Appeal Decision

Appeal Ref: APP/T2350/W/23/3322801

Pinfold Farm, Preston Road, Ribchester PR3 3YD

- The appeal is made under section 78 of the Town and Country Planning Act 1990 against a refusal to grant planning permission.
 - The appeal is made by Mr A Davies, Alan & Anne Davies Settlement 2014 Trust, against the decision of Ribble Valley Borough Council.
 - The application Ref 3/2022/1180, dated 21 December 2022, was refused by notice dated 13 March 2023.
 - The development proposed is demolition of approved domestic dwelling to new improved energy efficient domestic dwelling.
-

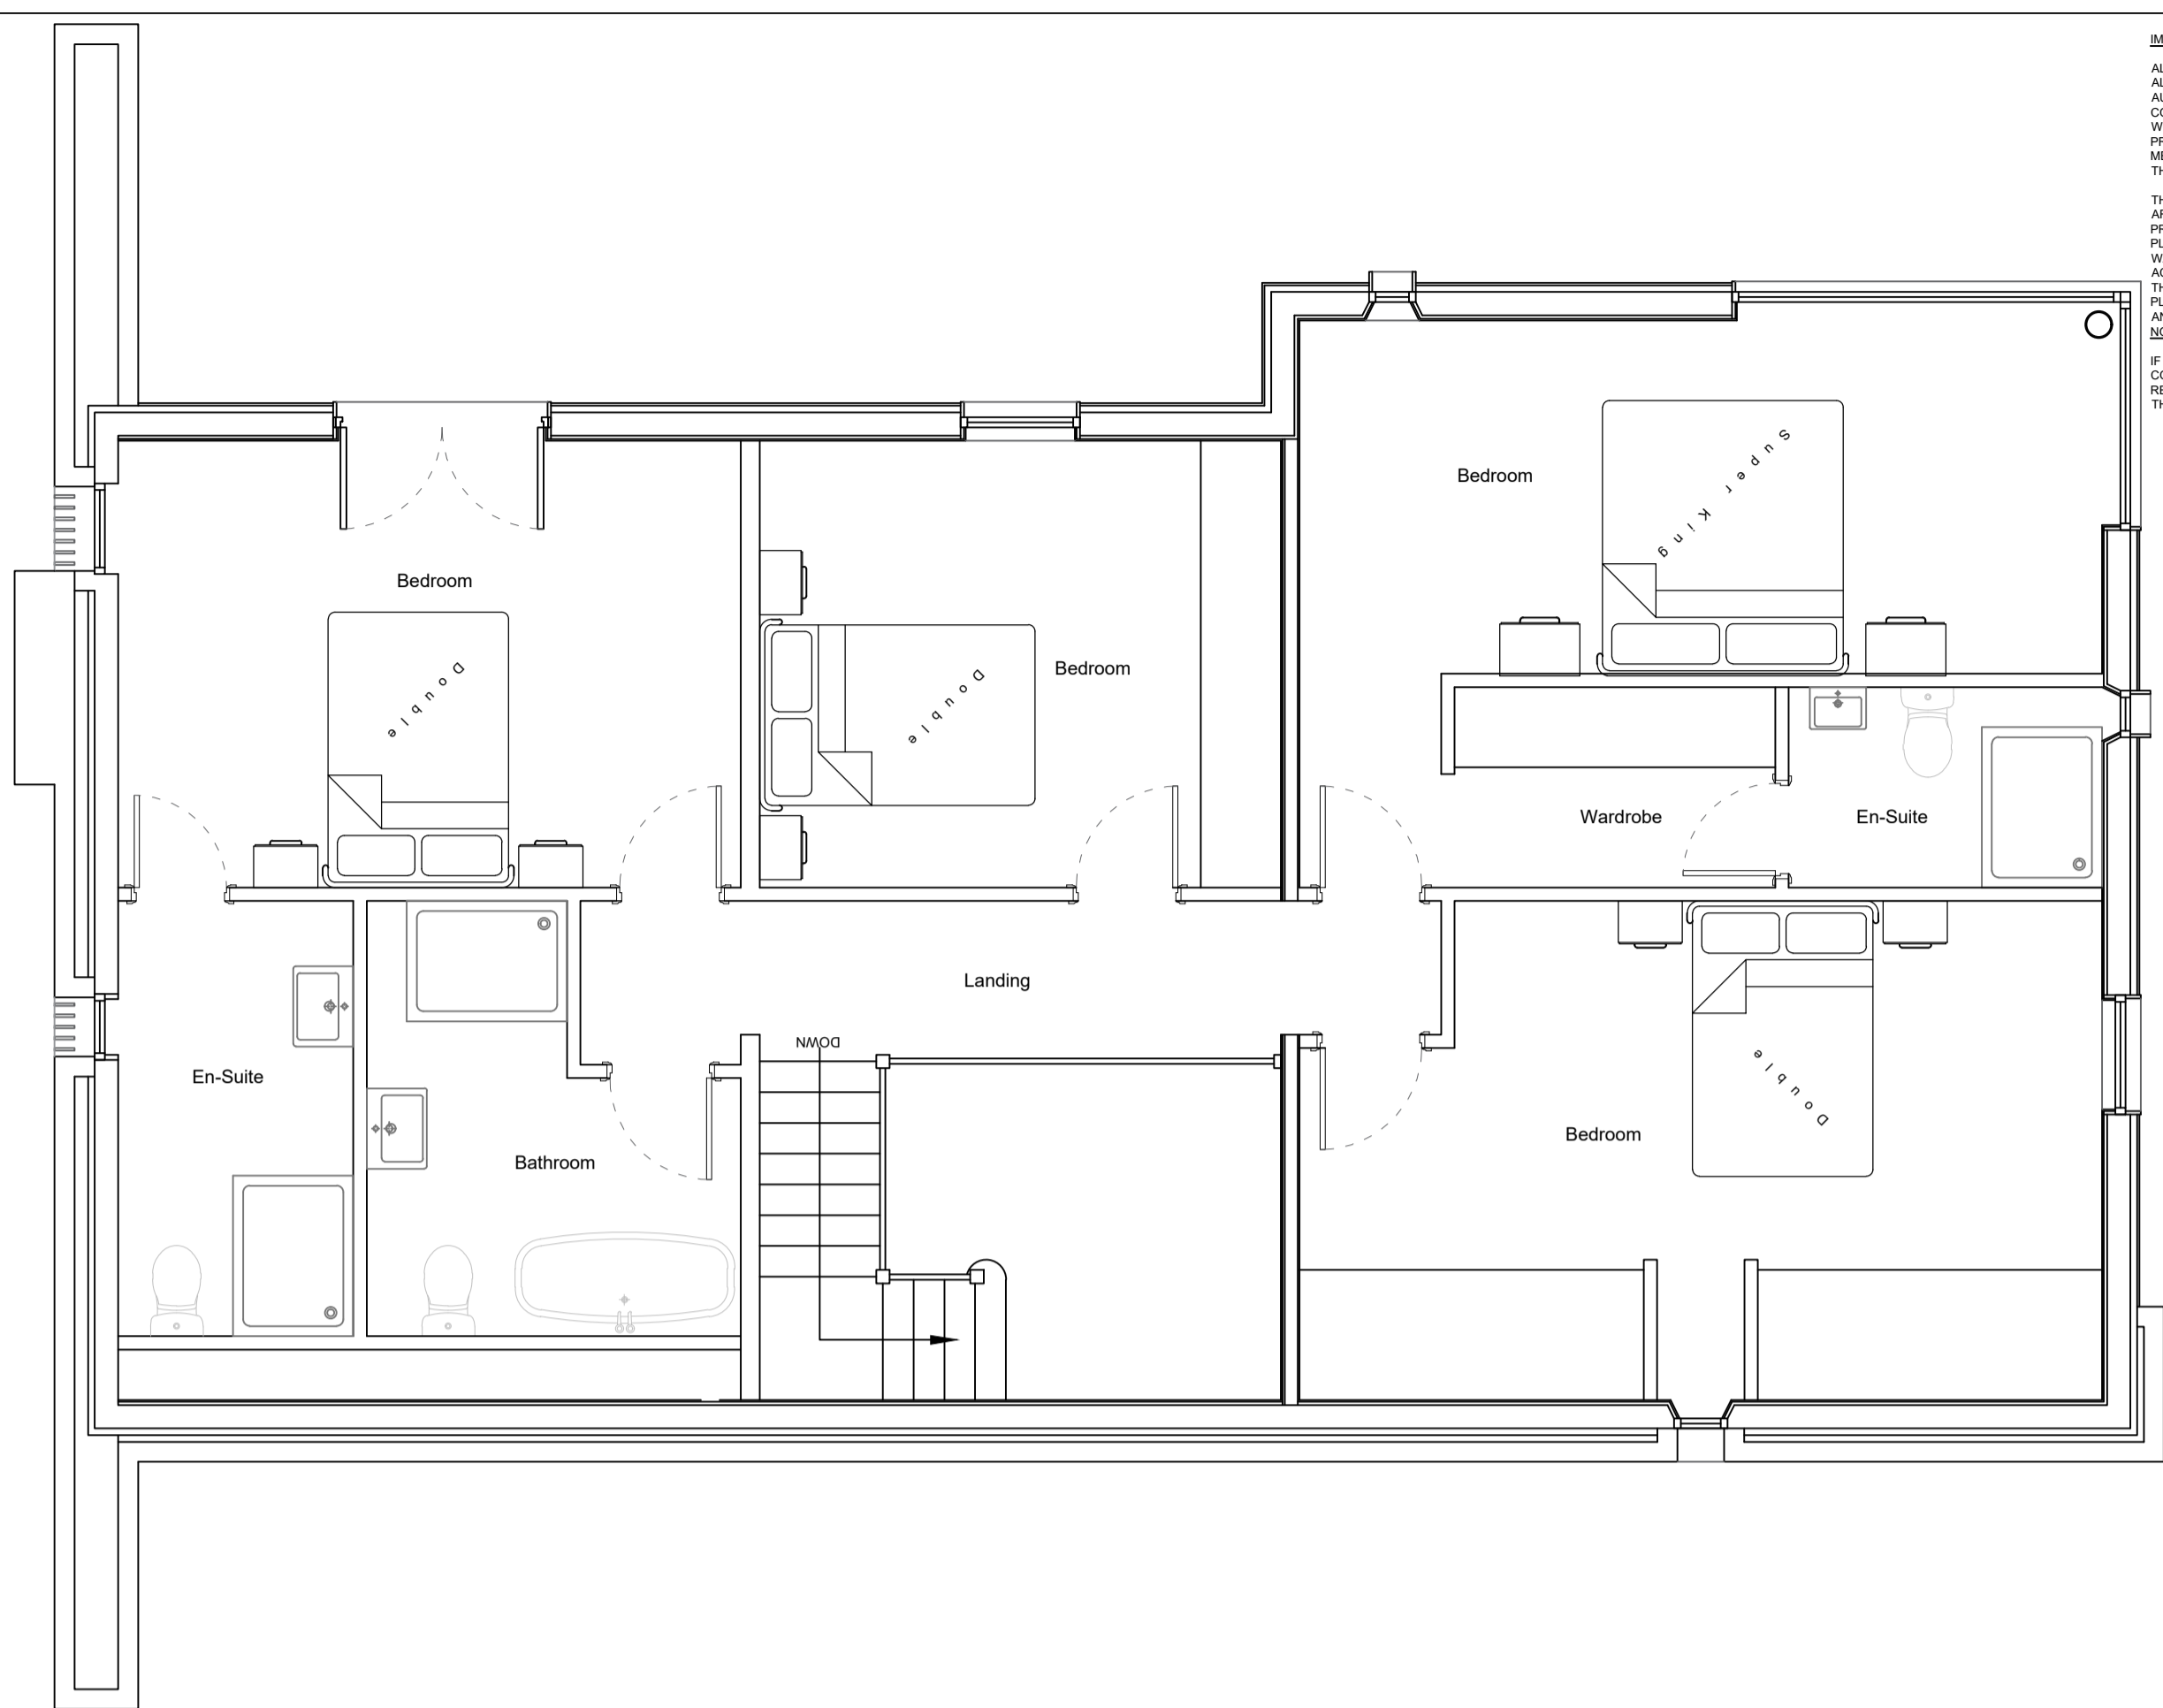
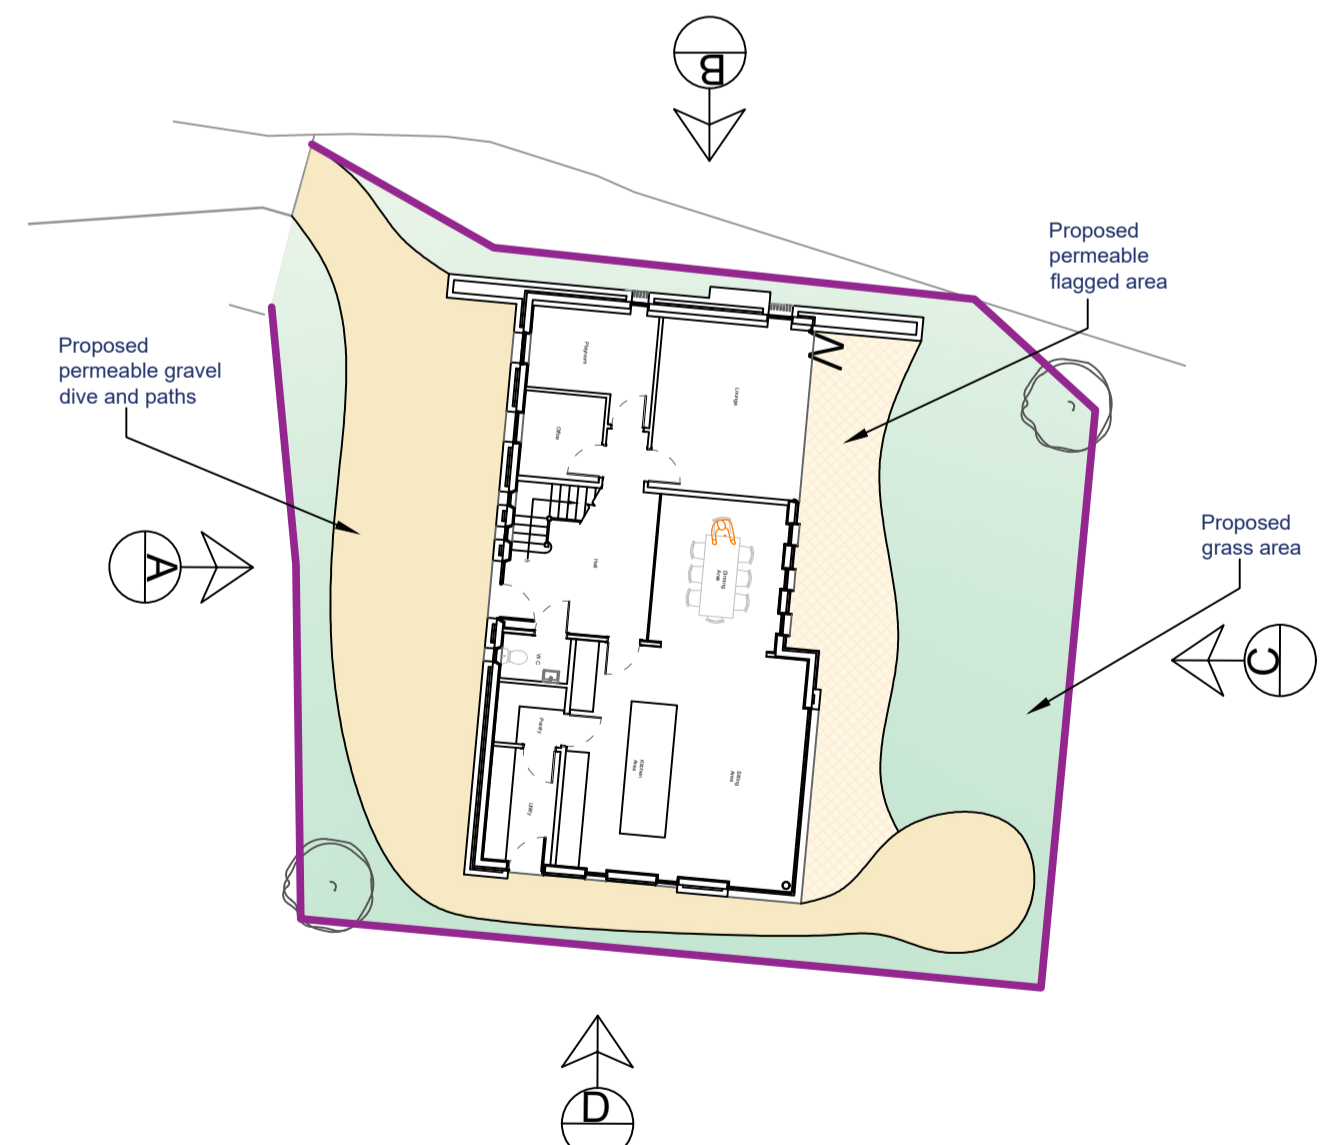
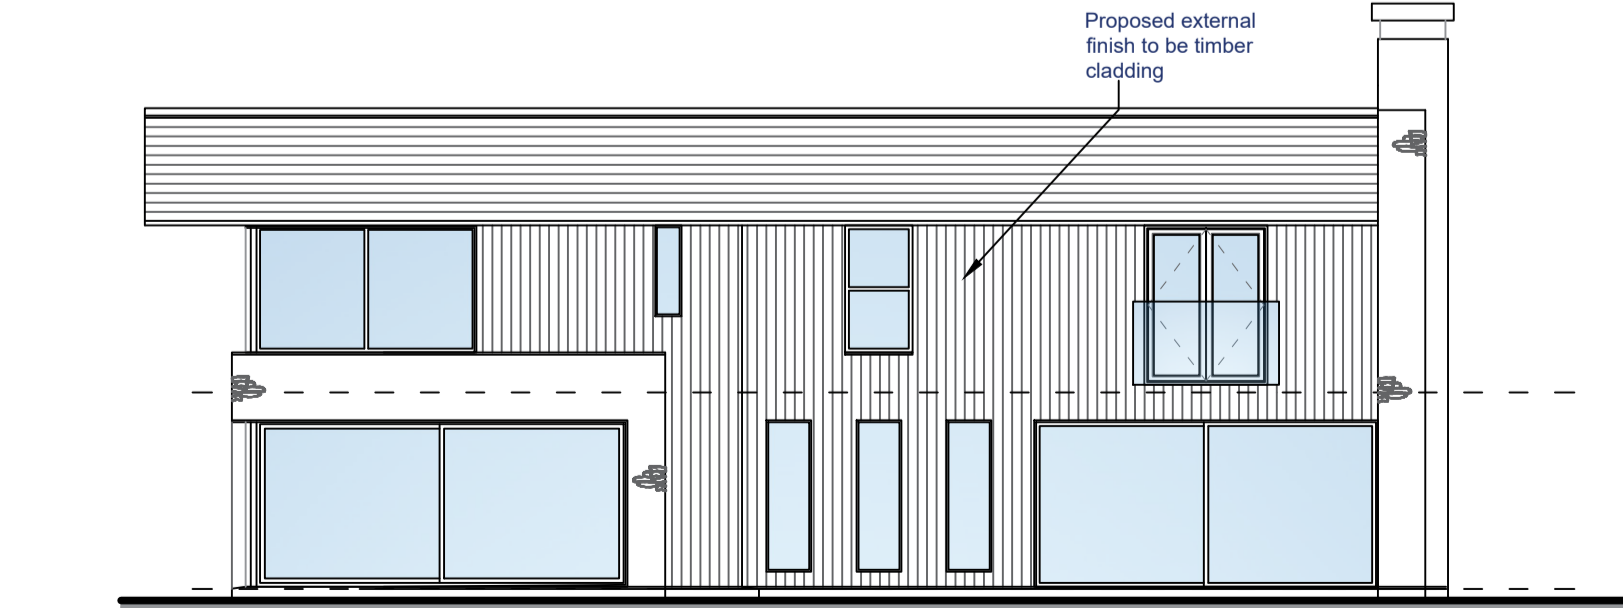
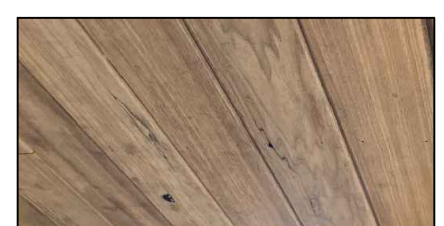
16. Whilst the proposed dwelling would be constructed in stone and timber to match the existing buildings on the site, it would not be of a traditional or characteristic form, with its asymmetrical roof, external chimney, and overhang of the roof. The modern design would be unlike any other buildings on the wider farmstead, and from what I could see of the local vernacular.

17. Moreover, the fenestration would include narrow windows, but also extensive areas of glazing on the rear elevation, and numerous openings on one of the side elevations. These, including a wraparound window, would appear discordant in this location. The variance in the style and form of openings would result in an incoherent design, not reflective of the character of the area. Overall, this would result in the building appearing overly domestic and incongruous in this location. Furthermore, as it would be higher than the existing building, it would be more prominent and visible when approaching the site from the direction of Ribchester.
